Planning (Listed Buildings and Conservation Areas) Act 1990 (as amended)

Application No: LU/162/20/L
Site Address: 20 Western Road Littlehampton BN17 5PG
Description of works: Listed building consent for the repointing of front elevation & replacement of rear doors.

Drawing title
Rear Elevation

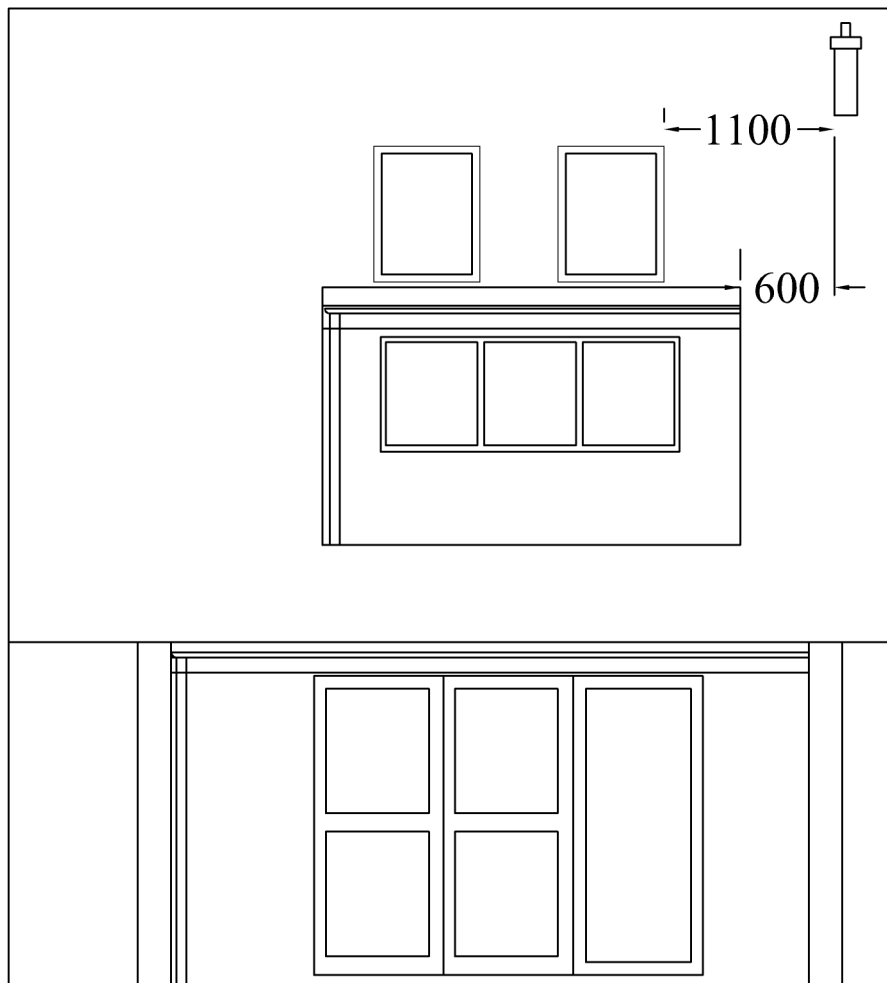
The material used for re-pointing should be in keeping with other properties in the vicinity. Ideally, the doors should be painted wood
